# The Planning Inspectorate

Our Ref: TR010039

### **Application by Highways England for an Order Granting Development Consent for the A47 Wansford to Sutton scheme**

#### **Advice following issue of decision to accept the application for examination**

HE551494-GTY-HGN-000-DR-CH-35002

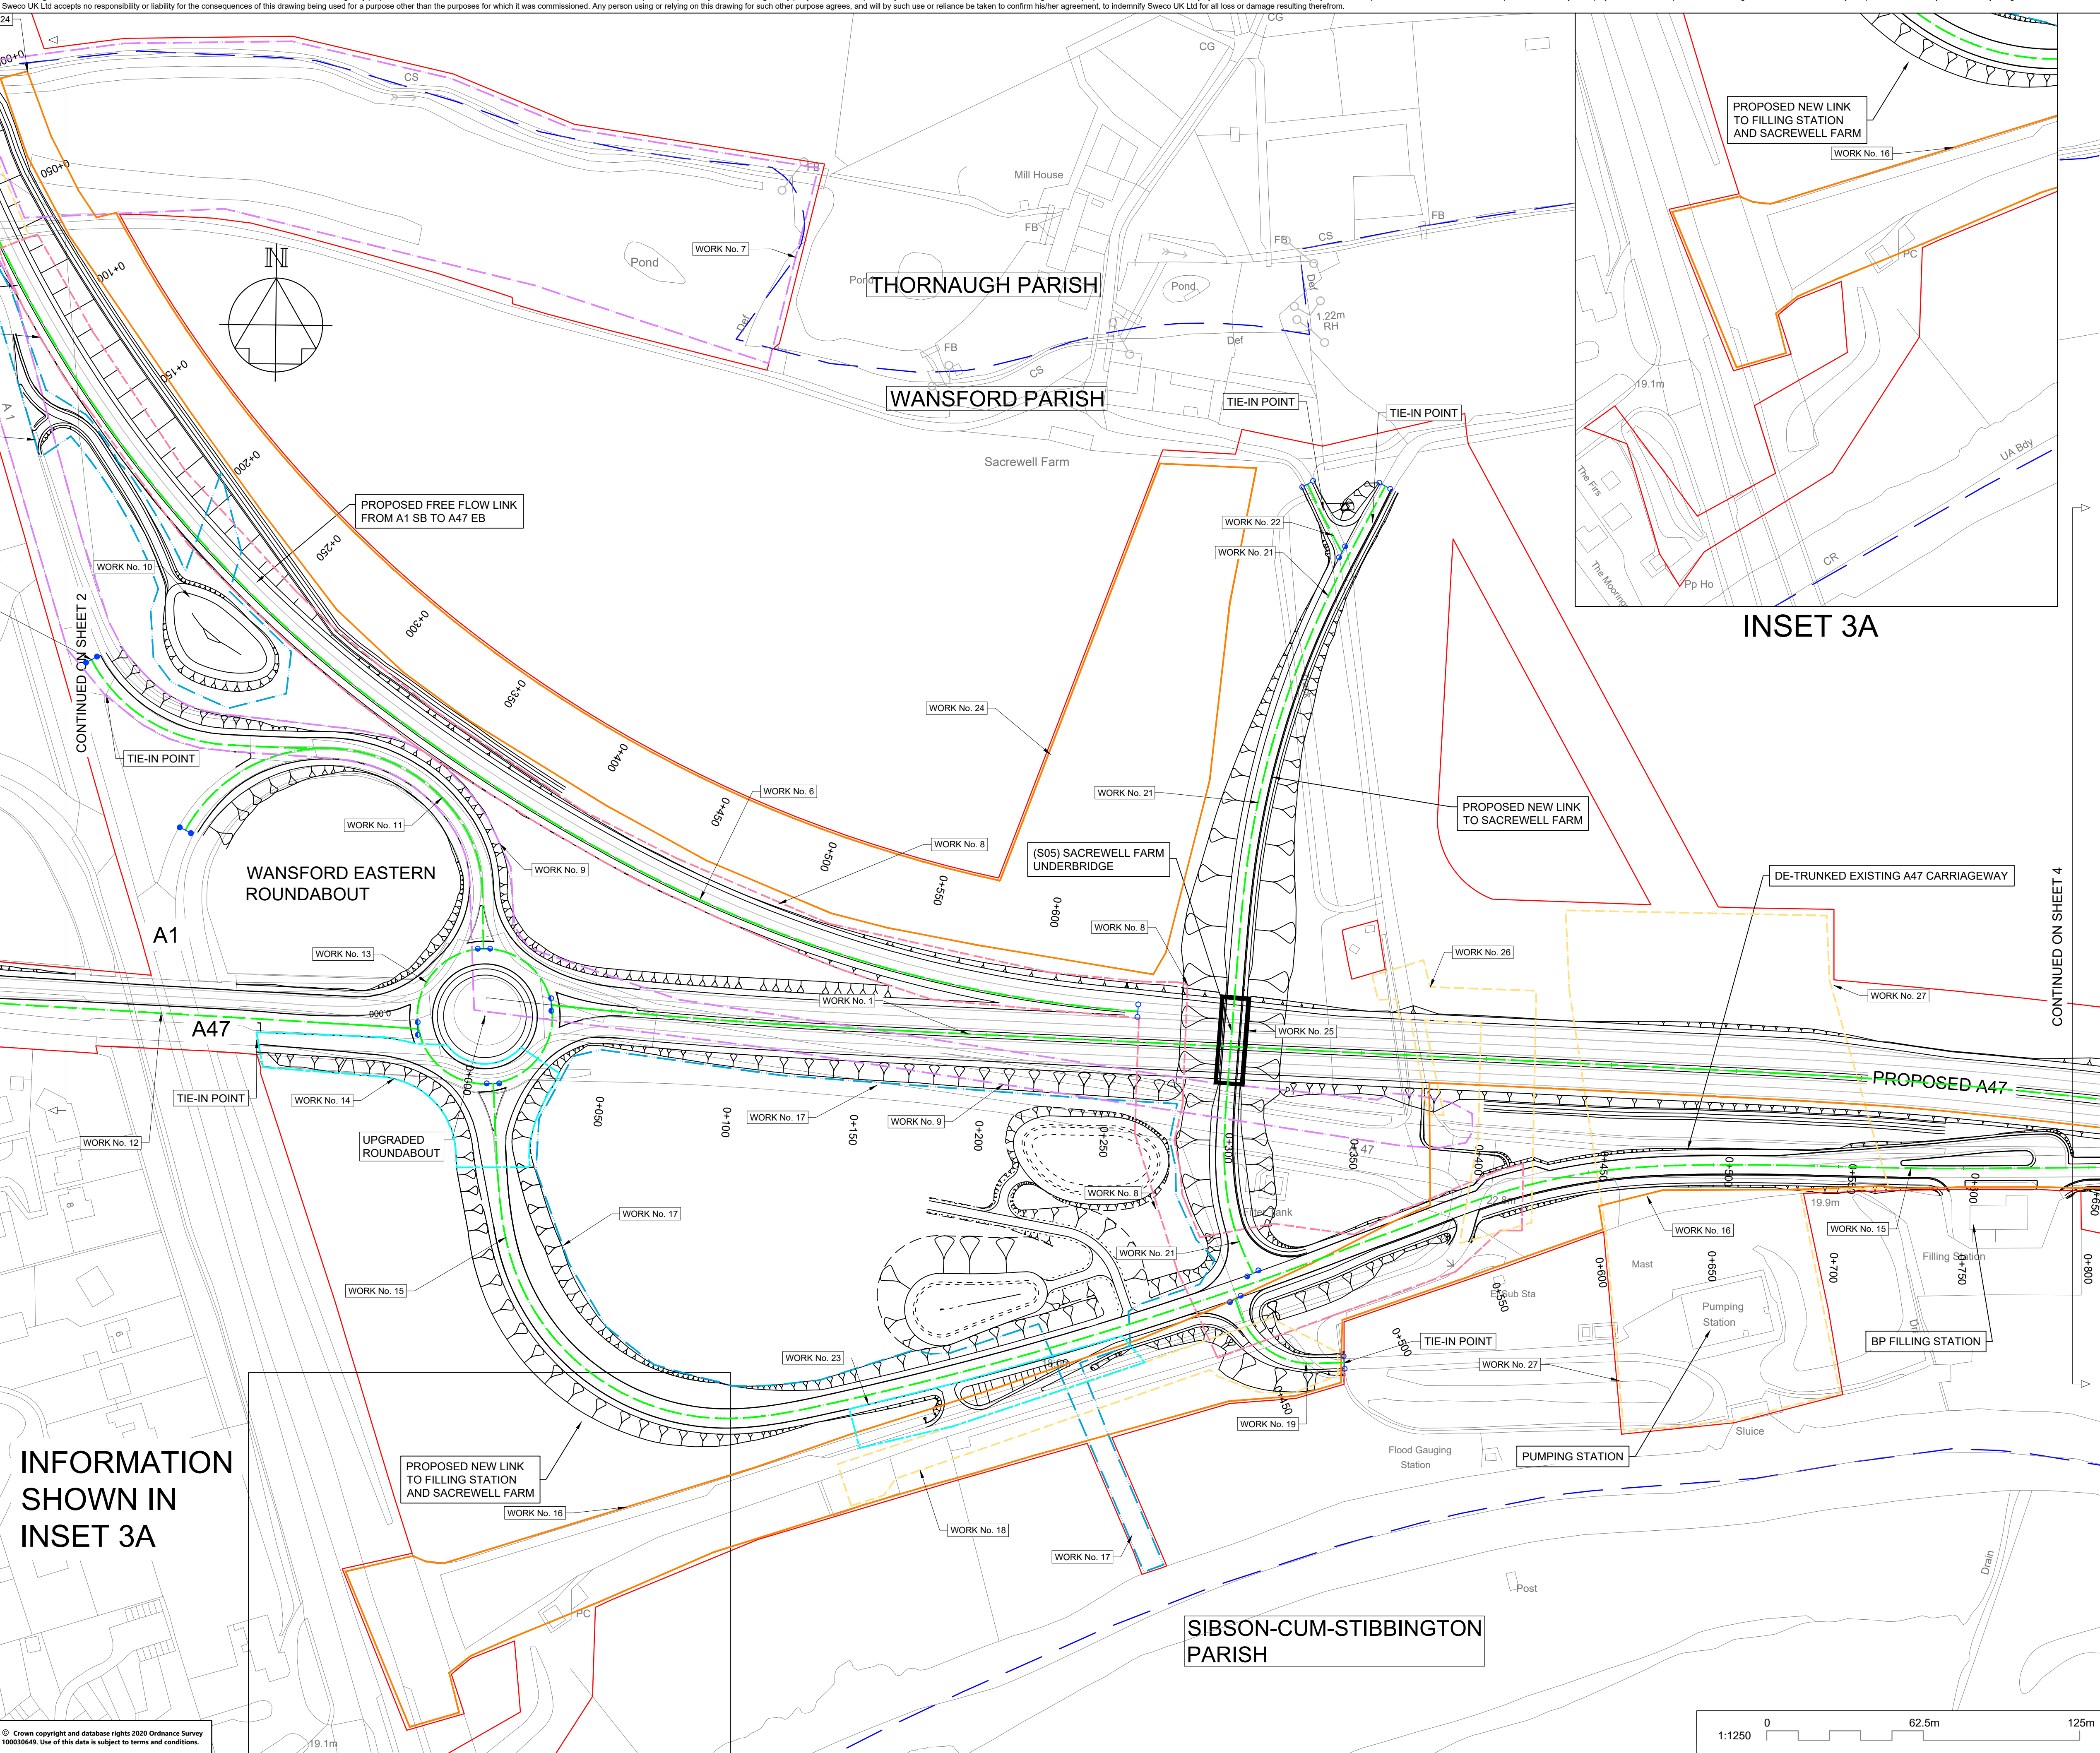
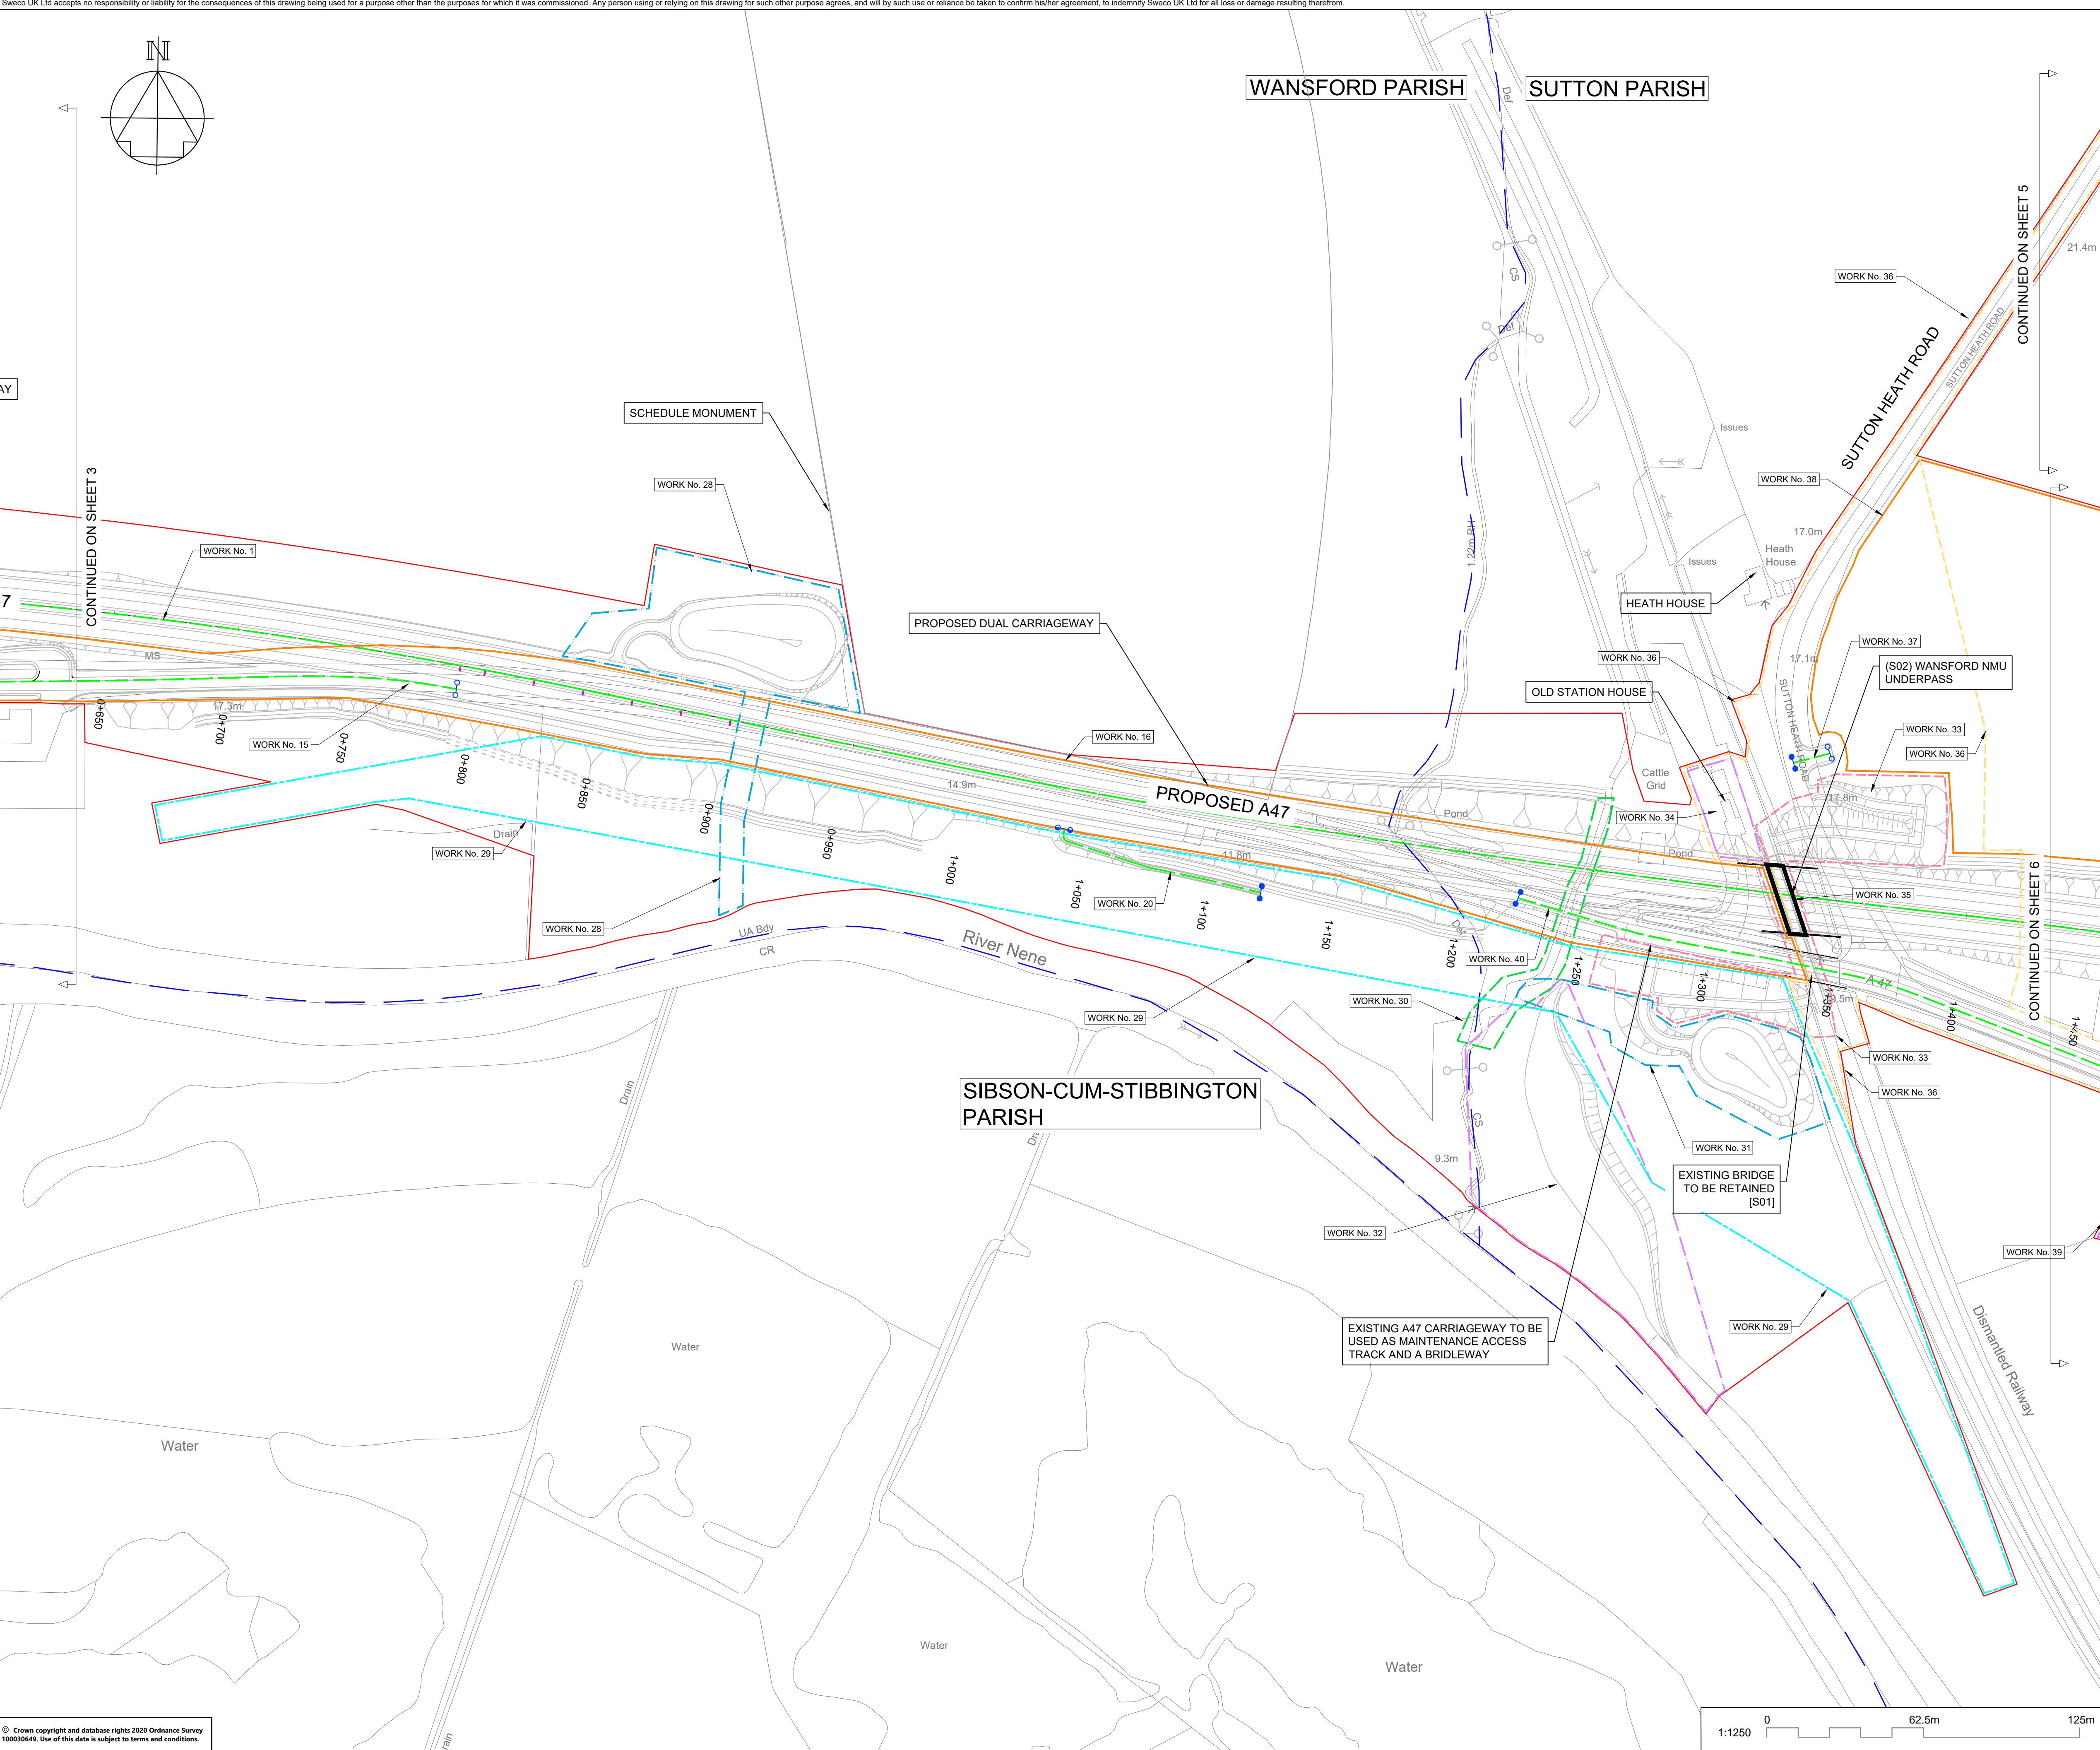
The Works Plans (Doc 2.3) do not clearly show the location and extent of the proposed compounds. The Inspectorate identified other minor discrepancies while checking the plans submitted as part of the application documents. Examples of errors are provided in Box 30, and the Applicant is advised to thoroughly check the plans for any corrections necessary. With this in mind the Applicant may want to consider submitting a revised set of Works Plans that:

- show the extent and location of the construction compounds; and

- represent the extent of the proposed works with annotations that are much easier to follow.
